The views of the **Arun District Conservation Area Advisory Panel** are as follows:

Application No: BR/242/21/OUT

Site Address: Land rear of 94-100 Hook Lane Bognor Regis PO22 8AT

Description of Works: Outline application with all matters reserved except access for the demolition of existing bungalow to form new access for 6 No. detached chalet dwellings (resubmission following BR/124/21/OUT). This application may affect the setting of listed buildings & may affect the character & appearance of the Upper Bognor Road & Mead Lane Conservation Area.

2. **Sc** Figure 2: Indicative Proposals.

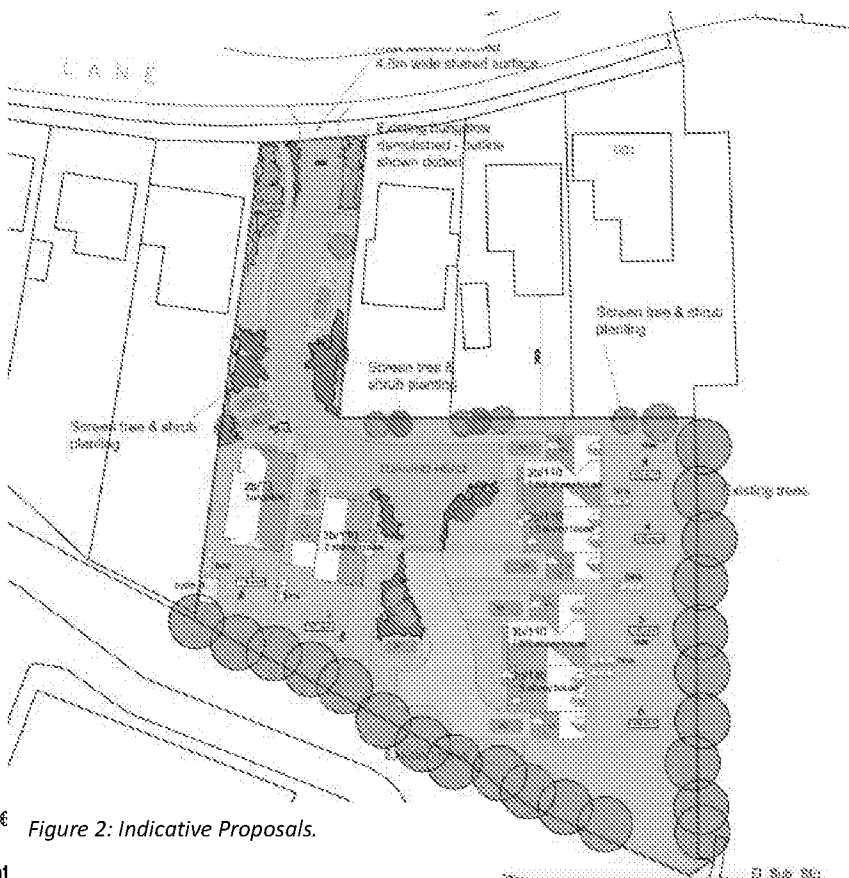
An illustrative layout has been submitted with the application which would appear to show that six dwellings could be accommodated within the site without the loss of the boundary planting but the Council needs to ensure that this is the case; perhaps consulting an arboriculturist.

The view of 'no objection' by the Panel is subject to the Council being fully satisfied that six dwellings can be accommodated within the application site without the loss of the important boundary planting.
